Recommendation Report for Planning Permission

REF NO: LU/249/19/PL

LOCATION: 48 & 50 High Street
Littlehampton
BN17 5ED

PROPOSAL: Change of use of No 48 from Licenced Betting Office & Adult Gaming Centre (Sui Generis) to Retail (A1 Shops) & No 50 from Retail (A1 Shops) to Licenced Betting Office & Adult Gaming Centre (Sui Generis).

No.50 EXISTING FLOOR PLANS & SHOP FRONT | 1:100

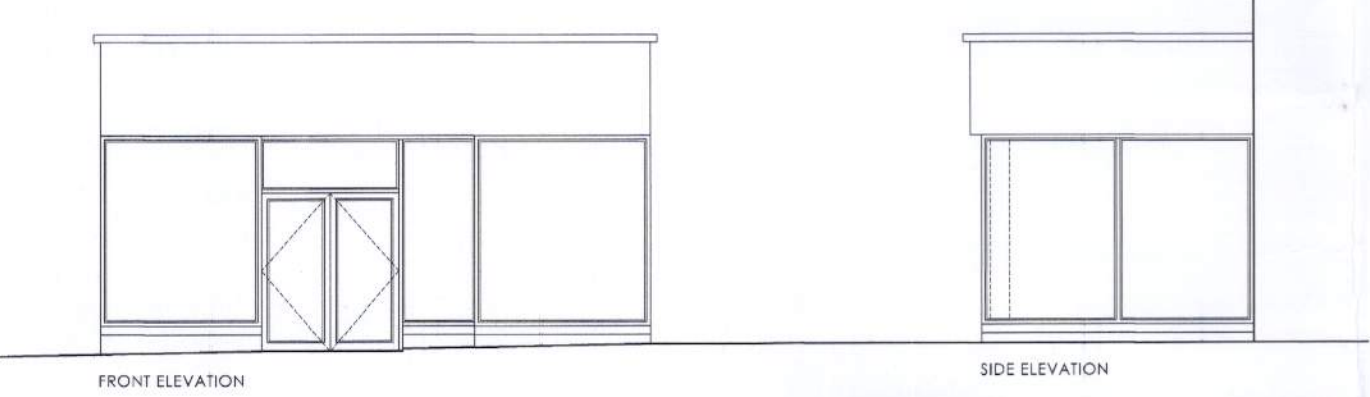
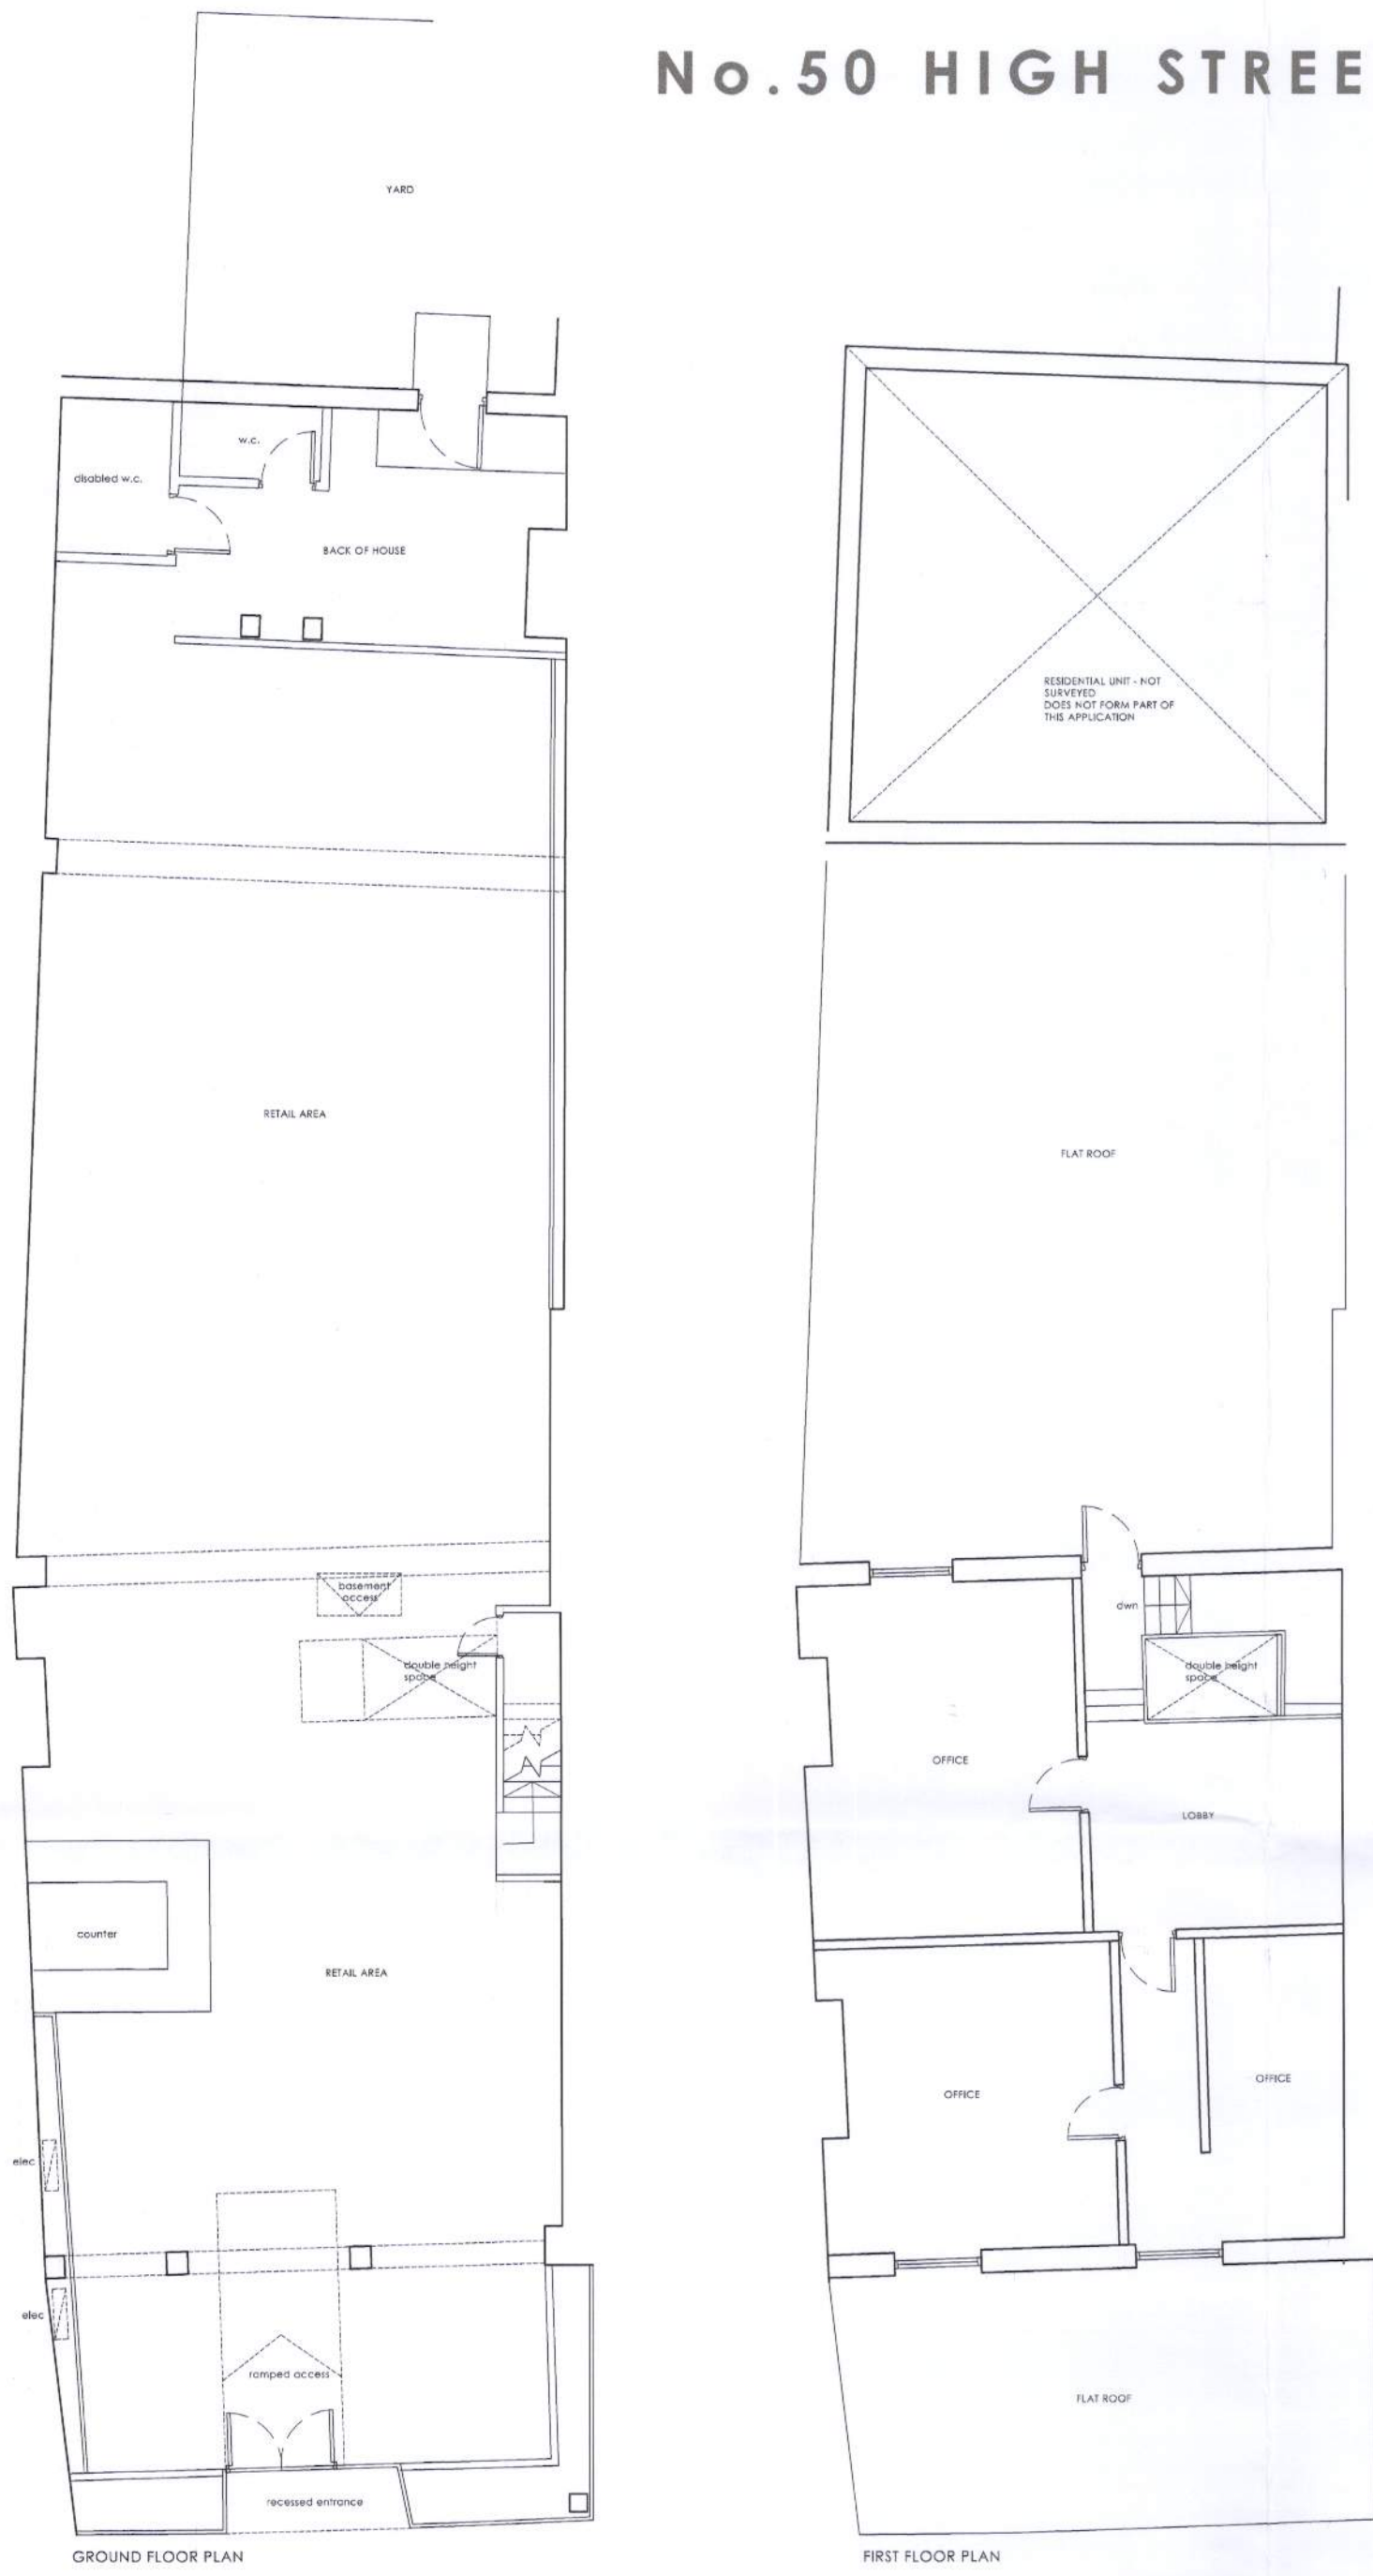
- Impossible to judge impact of proposals as the plans are limited regarding details of the design of the shopfront of the building. (Policy RET DM1)

Officers note the objection from the Town council whereby they consider that it is impossible to judge impact of proposals as the plans are limited regarding details of the design of the shopfront of the building. From an assesment of the submitted statement the applicant points out that there will be no external changes to the buildings other than the signage being updated and the removal of the window covering at number 48 This application does not include the signage and a separate application would have to be submitted, if it hasn't already been, for determination under the Control of Advertisements regulations (as amended). Therefore, Officers consider that the impact of the proposals can be assessed based on the submitted plans and information.

No.48 EXISTING FLOOR PLANS & SHOP FRONT | 1:100

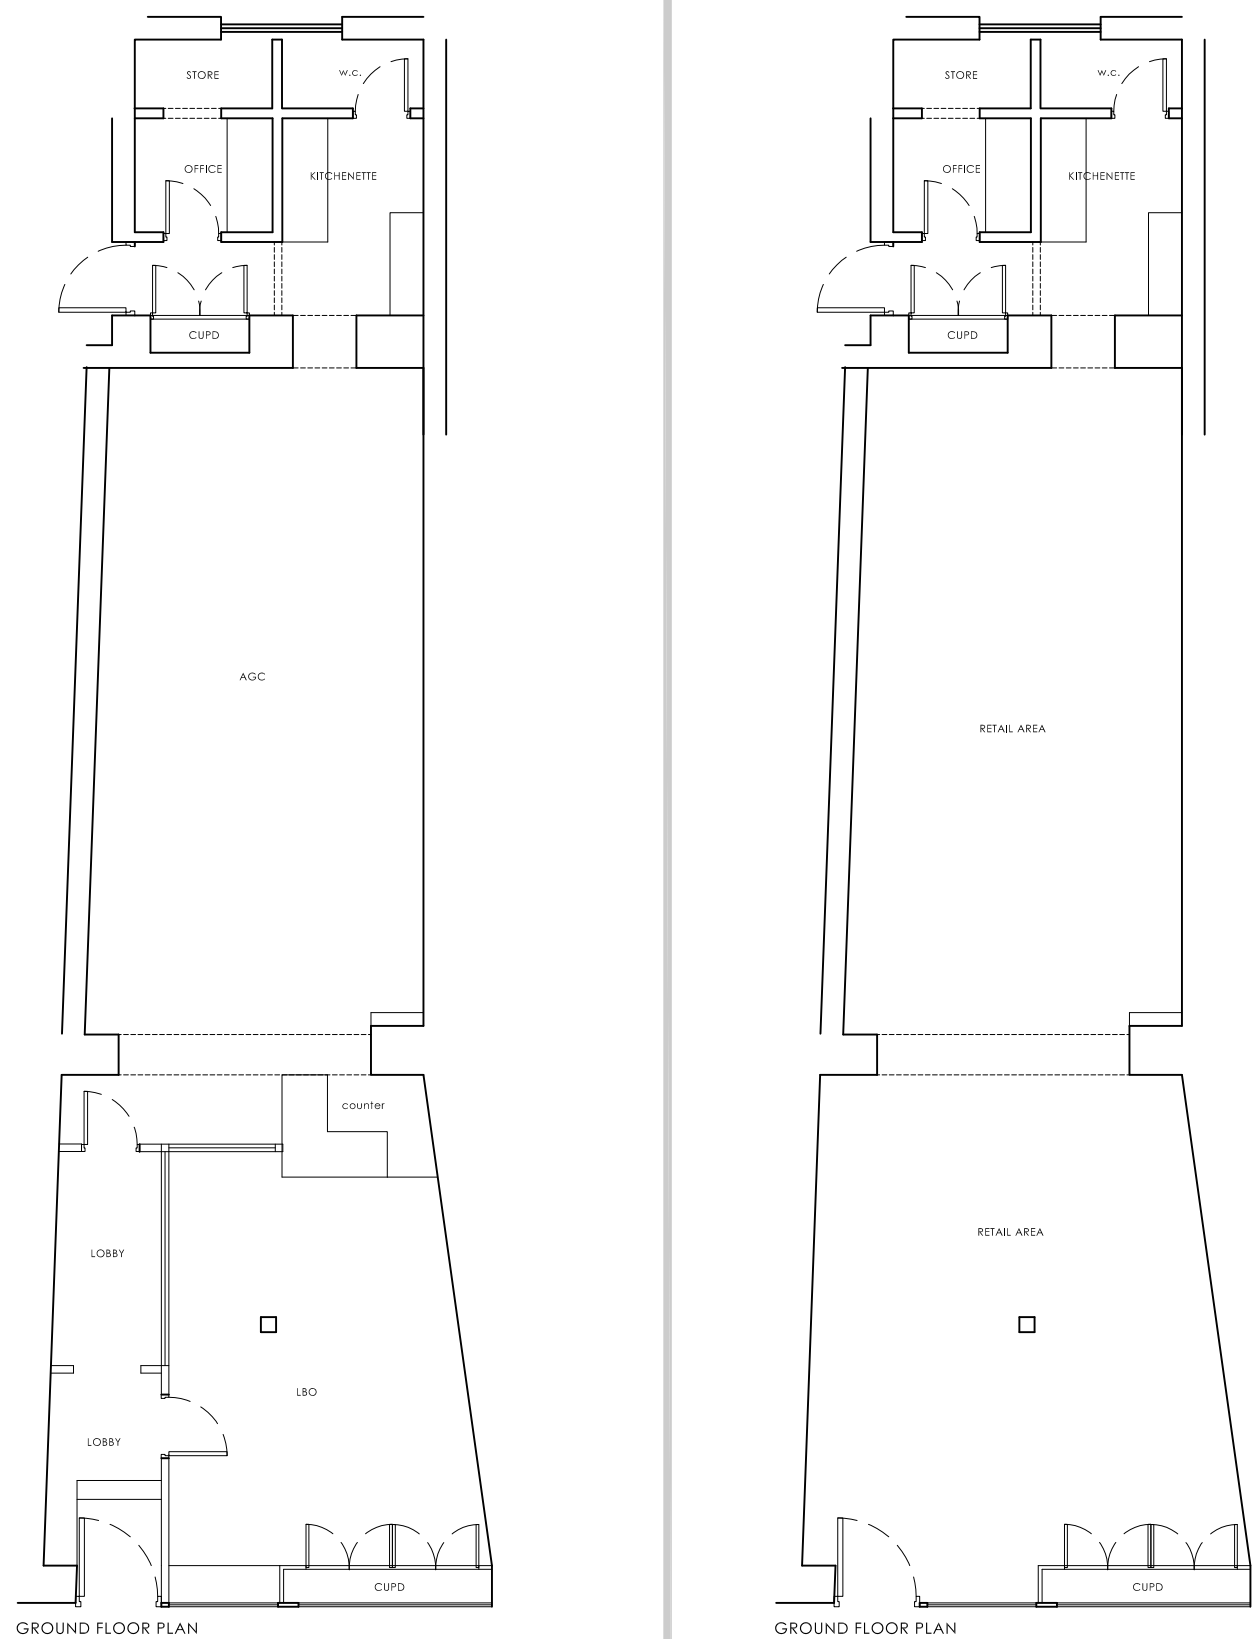
The works proposed within number 50 are the erection of an internal partition wall and creation of lobby along with the removal of the existing retail counter at ground floor. The proposed works within number 48 are the removal of the internal partition walls and internal door. One of the windows in the shop front at number 48 is covered up with a graphic of sports equipment and the word bookmakers above. The Applicant has confirmed, on the amended plan, that they intend for this to be removed thus reinstating a useable display window.
